**KIRKLEES METROPOLITAN COUNCIL
INVESTMENT & REGENERATION SERVICE**

**DELEGATED DECISION TO DETERMINE APPLICATIONS FOR
NON-MATERIAL AMENDMENTS**

Reference No: **2023/NM/91202/E**

Site Address: 2, Leefield Road, White Lee, Batley, WF17 8AW

Drawing Title  
**PROPOSED EXTN**

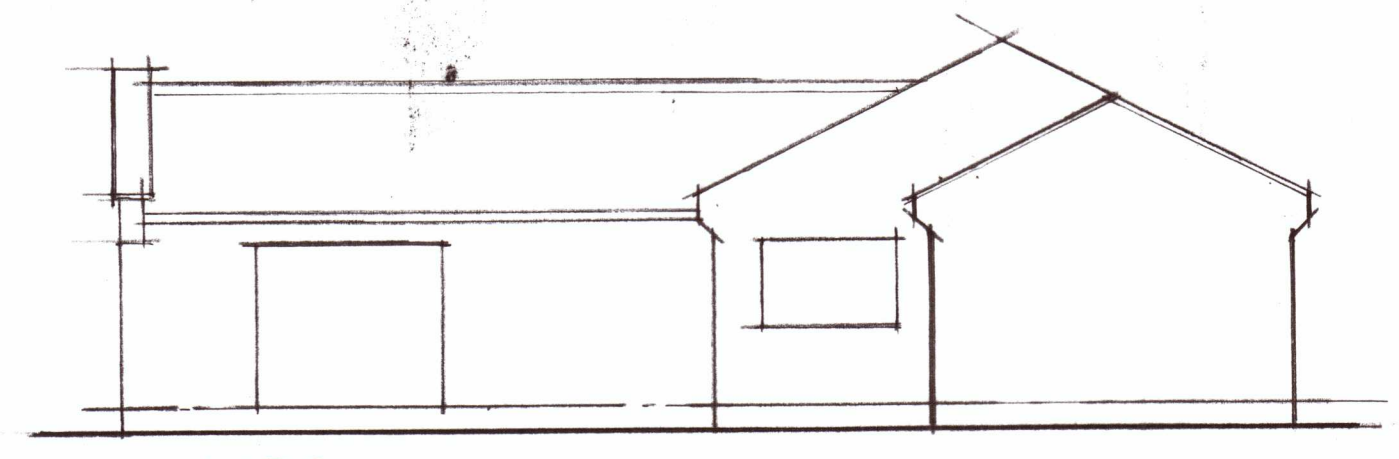
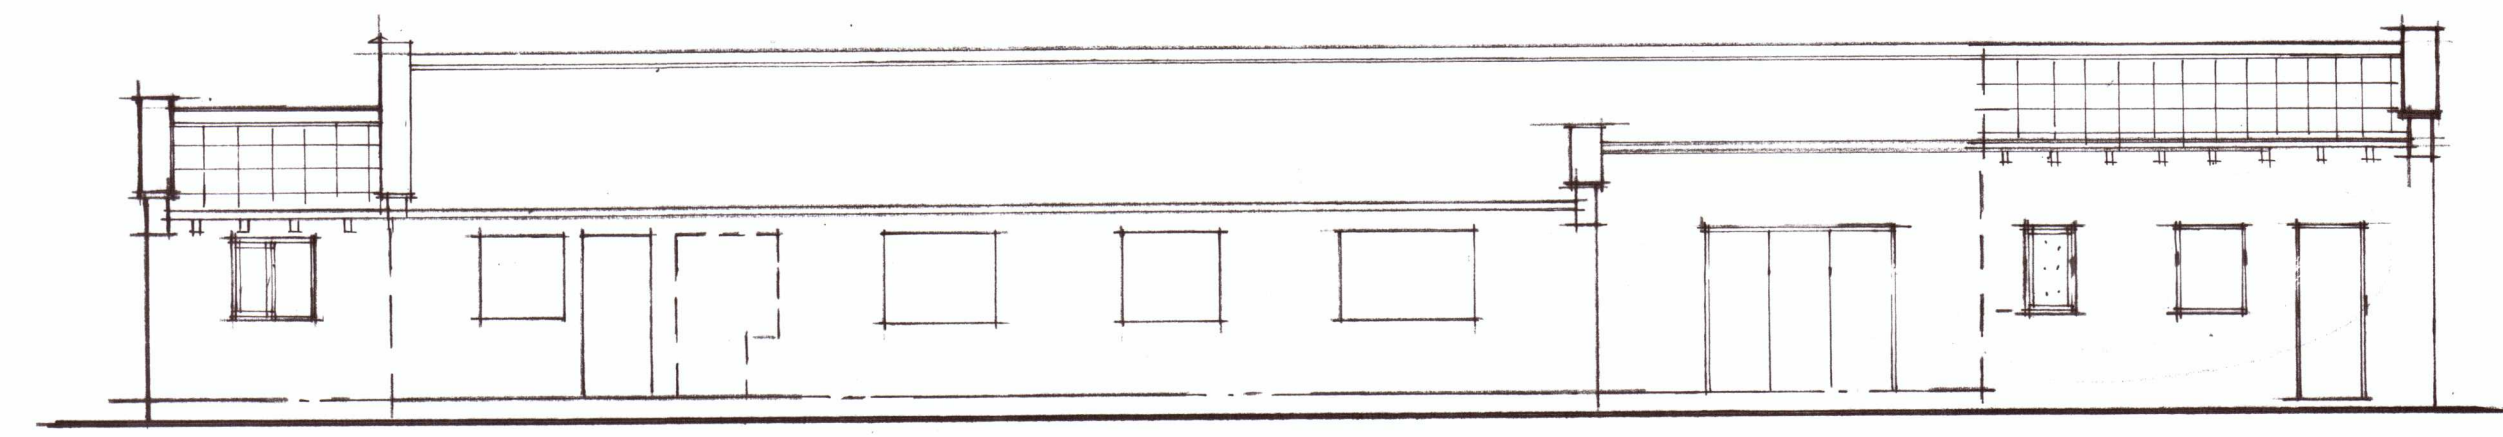
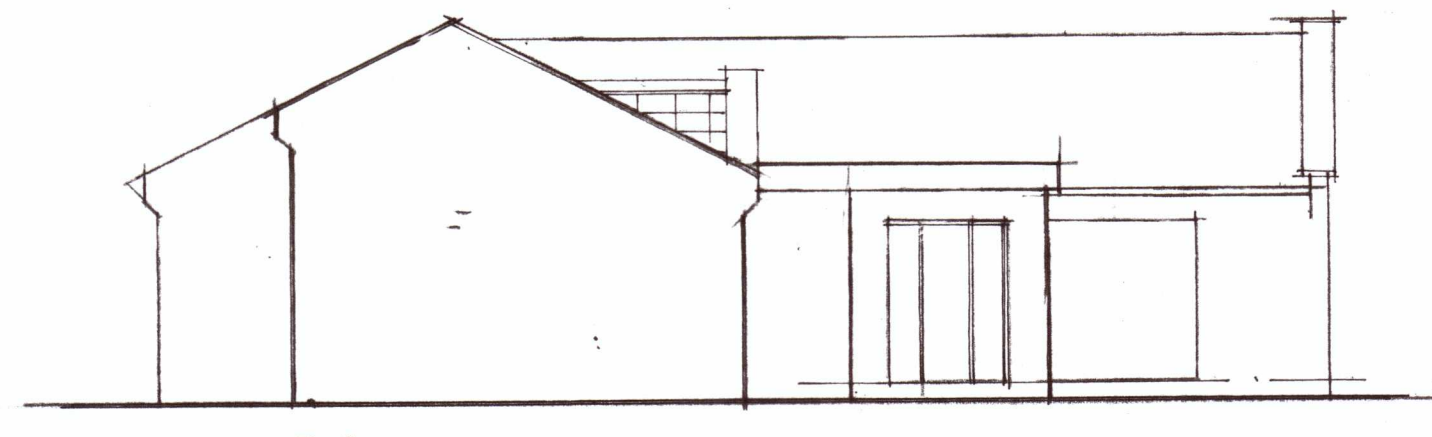
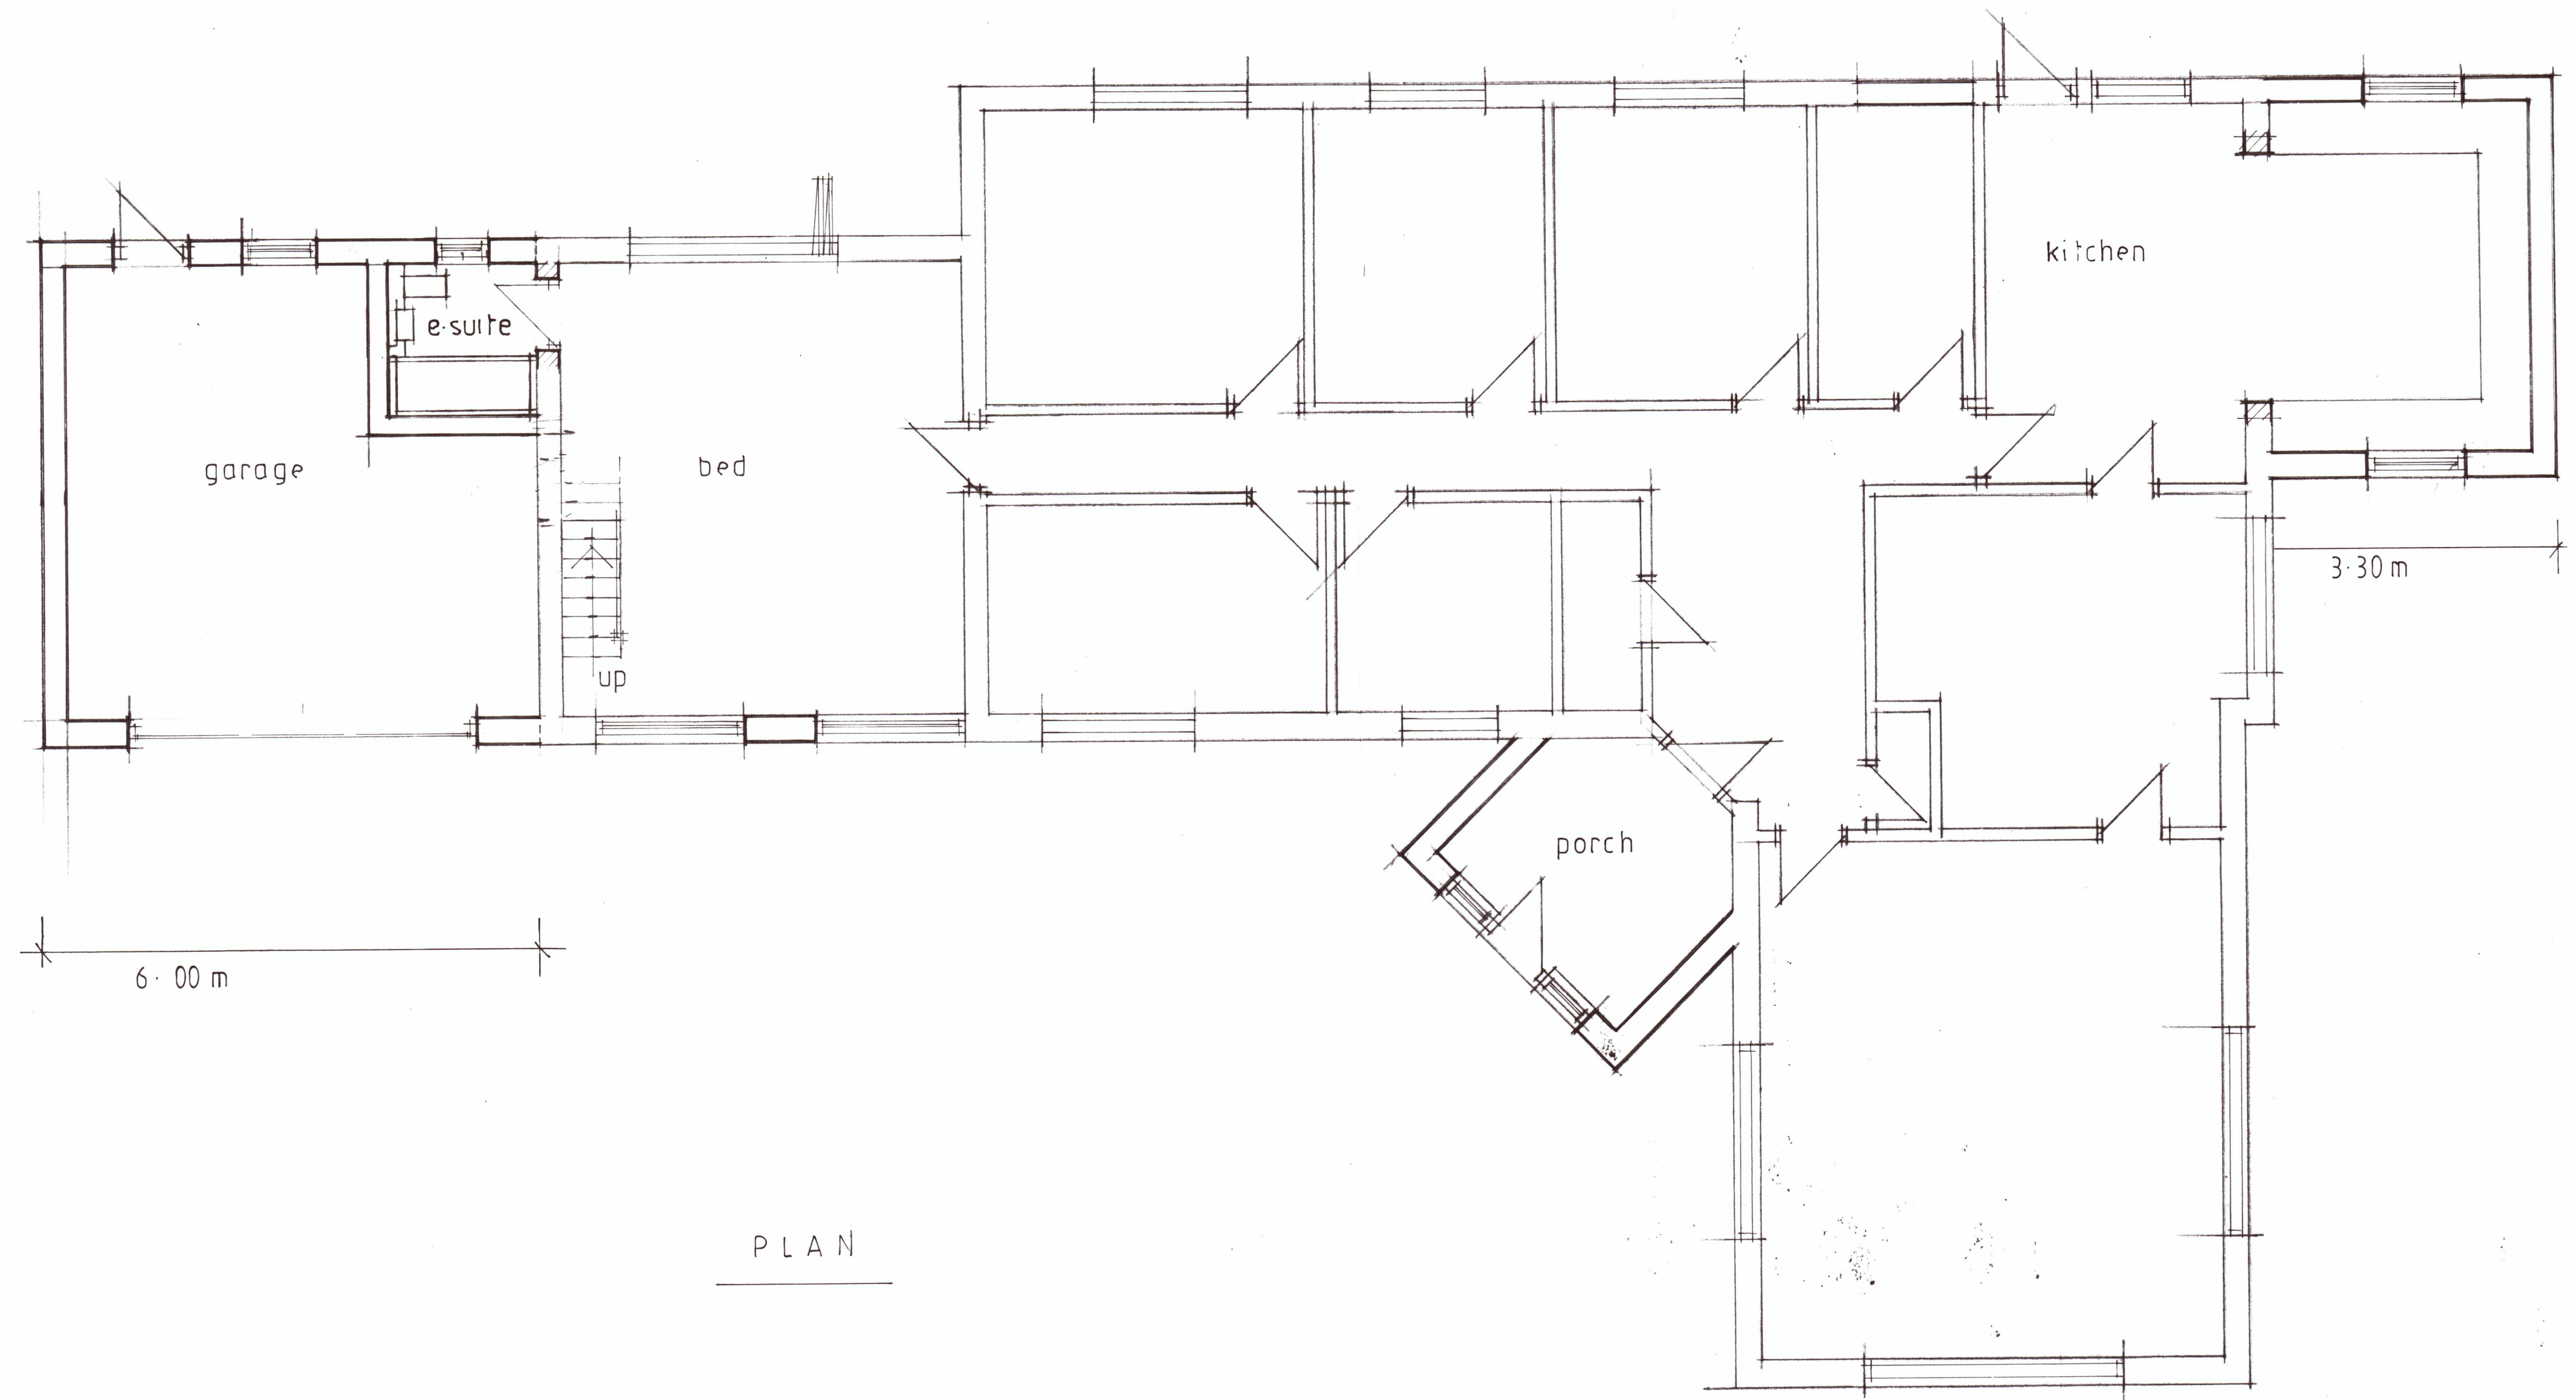
The submitted plans and application form indicate that the non-material amendment being sought is to amend the pitch roof on the porch to a flat roof, amendments to the windows in the rear elevation and a gable end roof over garage. The roof would also be finished in blue slate instead of concrete.

The proposed amendments to the openings in the rear elevation and roofing materials would not change the scale of the proposal. The amendment to the porch from a pitched roof to a flat roof, this would be a slight reduction to the scale. The proposed amendment to the garage roof would add a gable end feature to the garage roof. The proposed alterations to the roof type would change the appearance of the property whilst adding some additional roof space in the garage. This would be a relatively small addition and would therefore be inconsequential as the principal of development would remain the same, and it would not significantly change the scale of the original approval.

The proposed development would remain a significant distance from the neighbouring occupants to prevent any harm to residential amenity. Visually, the proposed amendments do change the appearance of the dwelling. The proposed change to openings would be minor and would not affect the visual amenity of the property. The proposed flat roof on the front porch would not be in keeping with the character of the property and would be in a prominent location. This would be detrimental to visual amenity and would need to be assessed under a full application. The proposed gable end to the garage would remain in keeping with the existing gable end feature and would therefore not be detrimental in terms of visual amenity. The original approval

conditioned that materials must match the existing and therefore if the applicant wants to amend the materials of the extended roof to materials not in keeping with the existing then this would be detrimental visually. If the applicant wants to amend the entire roofs materials this would require a full assessment under a planning application.

To conclude, the amendments shown on drawing '21/204 Rev.A' would not be in keeping with the existing dwelling and would therefore be detrimental in terms of visual amenity. Due to the failure to comply with the second test, the proposed alterations could not be considered under the NMA procedure; this is irrespective of whether tests 1, 3 and 4 could have been met. If the proposed extension was to be amended, a separate planning application would need to be submitted for the proposal to be assessed in terms of its impact on the visual and residential amenity.
